CITY OF ALBUQUERQUE

February 24, 2021

Re: Valencia (Active Adult Community (K18D080))

Based upon the information provided in your submittal received 2-19-2021, the above referenced plan cannot be approved for a construction permit until the following comments are addressed:

NORTH  
A1 SITE PLAN  
1" = 20'  
0 10' 20' 40'

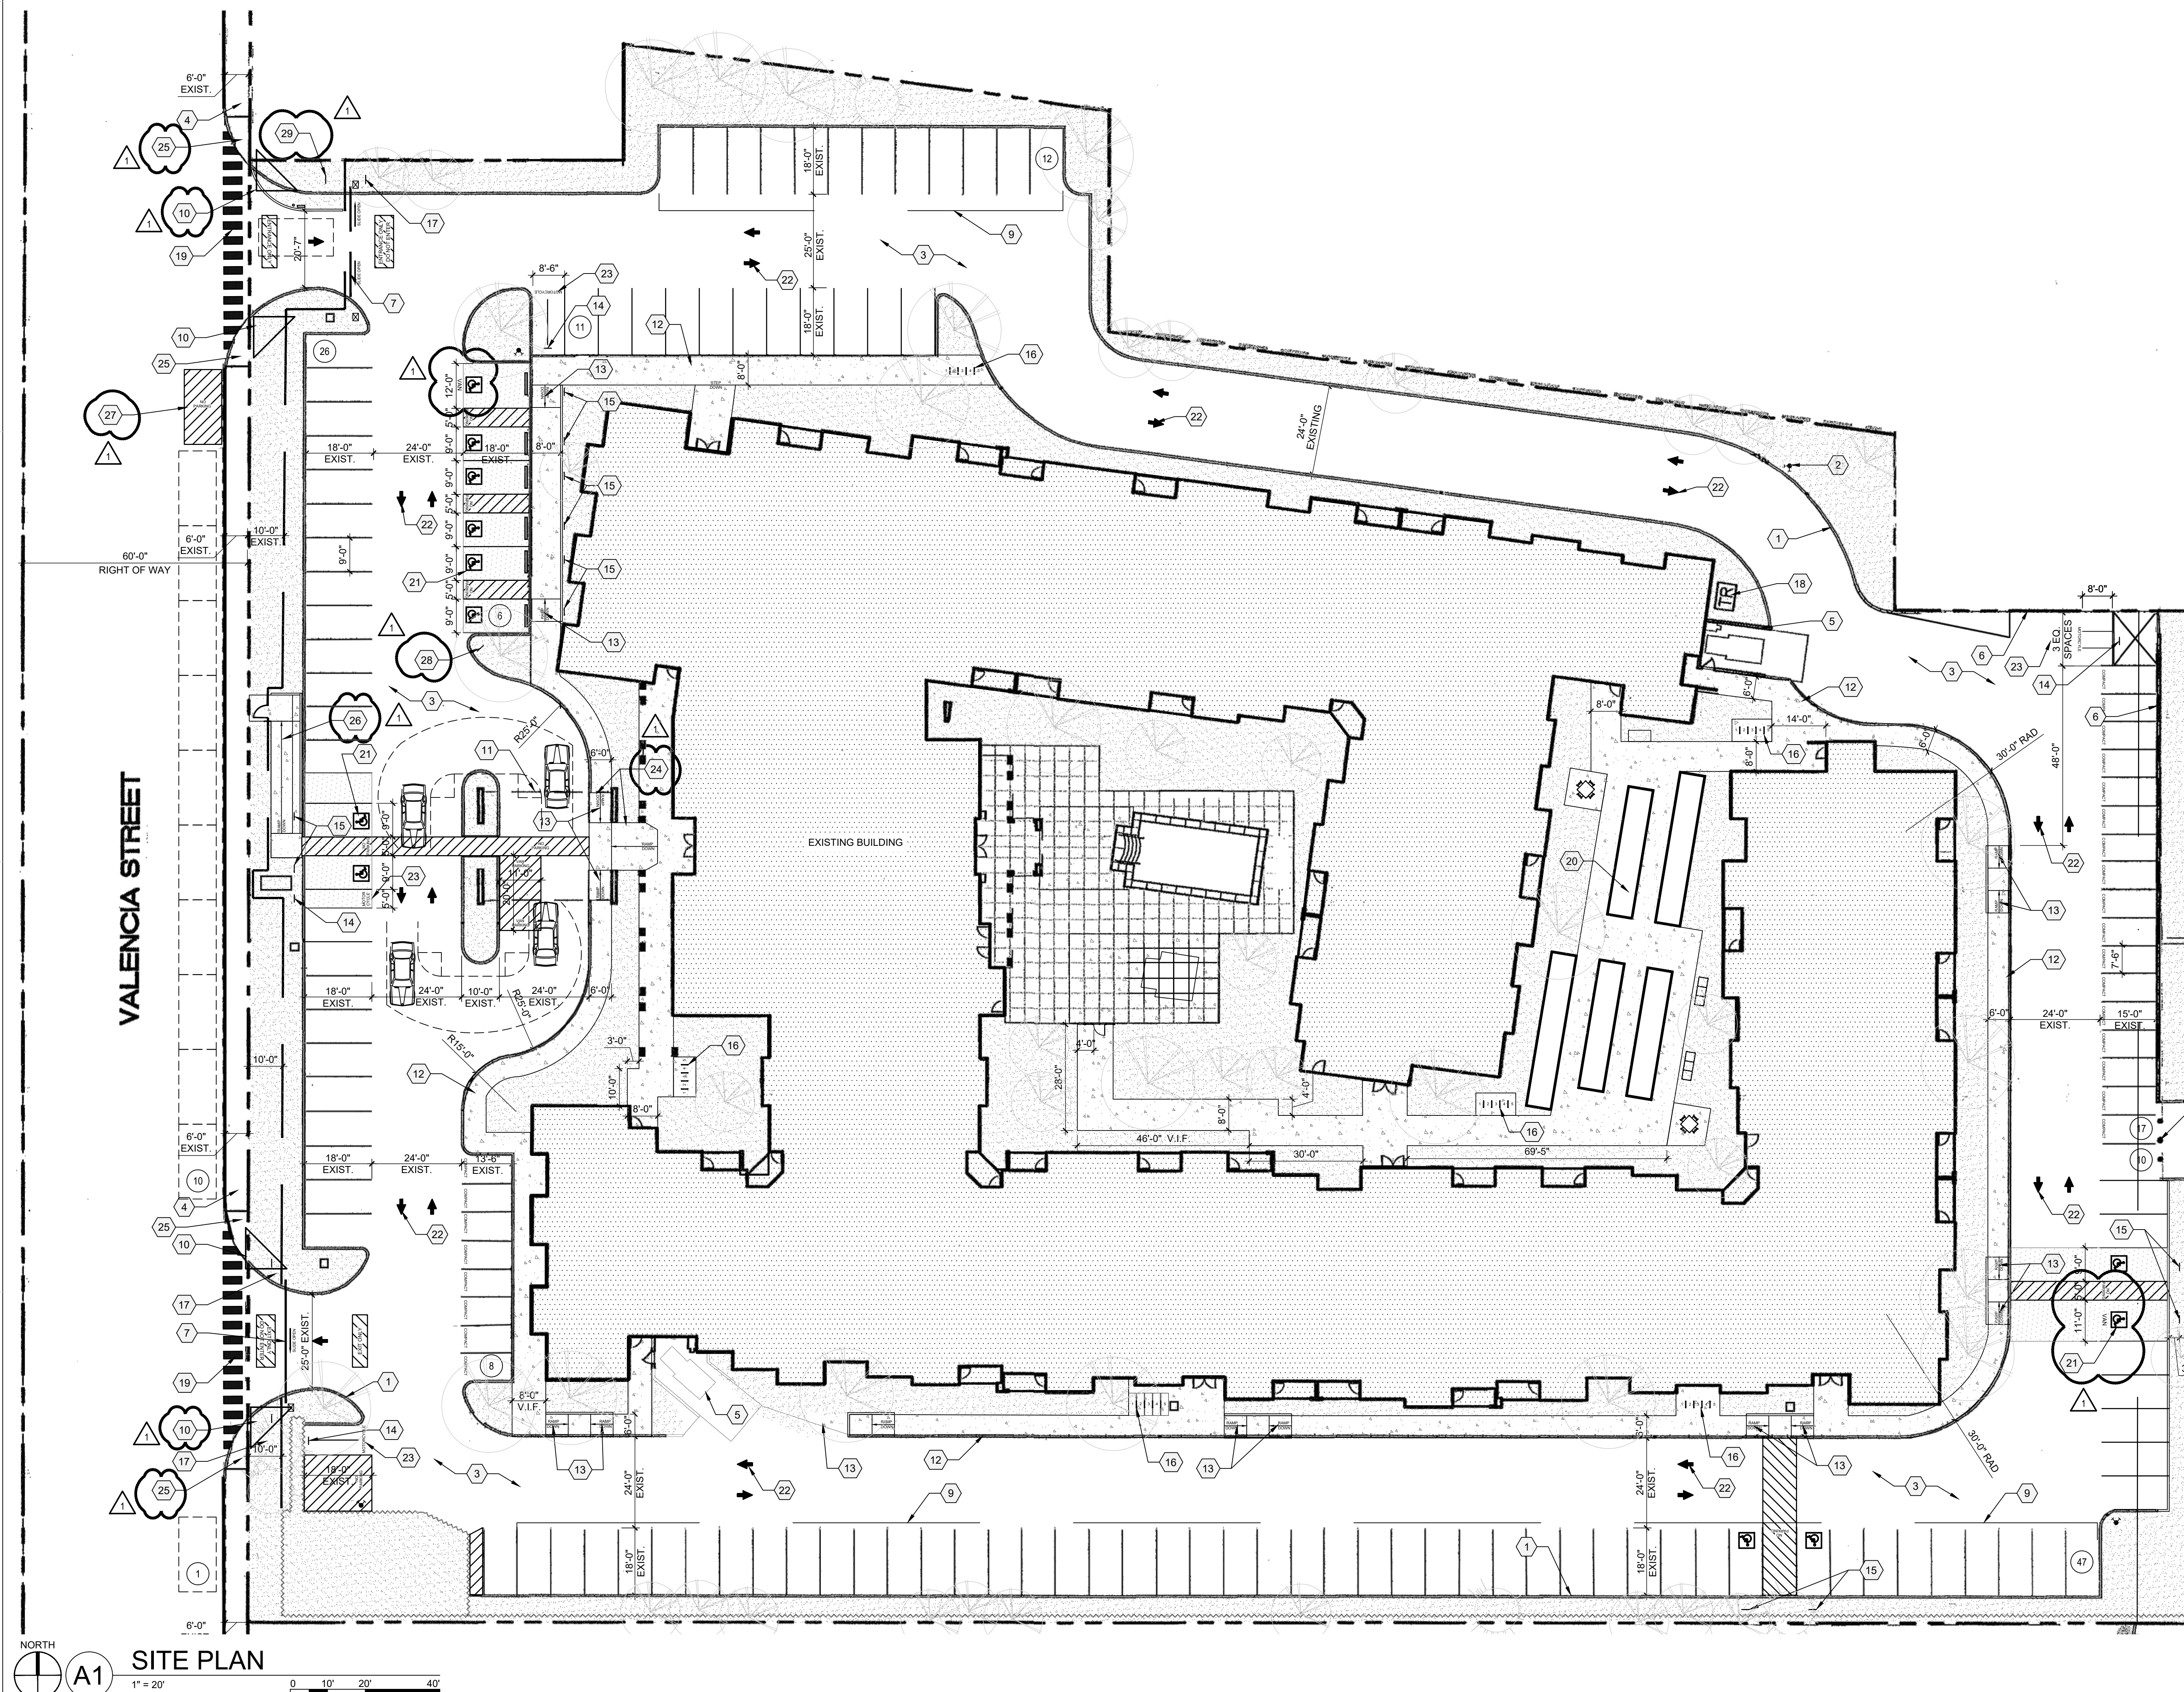
1. Obtain Solid Waste Approval prior to Traffic Circulation Layout approval.
2. If traffic is coming from the north entrance and the cars for the drop-off area are expected to be facing north in order to drop off passengers at the curb, demonstrate that this is feasible with a car turning template, and show pavement arrows and "Do Not Enter" signs if this area is expected to be one-way. (I just need clarification for this area.)

3. Show sight distance triangles behind the sidewalk projected to curb per the mini clear sight triangle diagram in the DPM. (The ones shown are placed incorrectly within the accessways.) Add the note, " Landscaping, signage, walls, fences, trees, and shrubbery between three (3') and eight feet (8') tall (as measured from the gutter pan) are not allowed within the clear sight triangle."

4. For the handicapped spaces and aisles at the southwest corner of the site, provide dimensioning.
5. For the entry gate, relocate the one-way sign from the east side of the gate to the west side of the gate for driver approaching the entrance from the street.

6. For the ramp to the public right-of-way, list slope on the site plan. Based on its length and potential vertical elevation difference, does it need a retaining wall and a handrail per ADA requirements? (It appears to based on the grade difference between the parking lot and the sidewalk.)

7. Call out slope of ramp shown to the front doorway from the drop-off area. (If this is existing, you may feel free to label it as existing ADA-compliant ramp if it is below a 1:12 slope and meets other ADA requirements.)

8. To allow for queuing to the gate to the north, stripe out a "No Parking" area where the northernmost parallel parking space is shown. This will allow for a minimum of two vehicles for queuing behind the gate.

9. For the exit gate on the south end, explain the operation of it. Will it shut once it detects that the car has left? (This gives enough time for the car to sit and wait for whatever vehicular and/or pedestrian traffic is clear before exiting onto the street.)
10. Call out existing ramps along Valencia to ensure sufficient ADA accessibility across the front of the property.
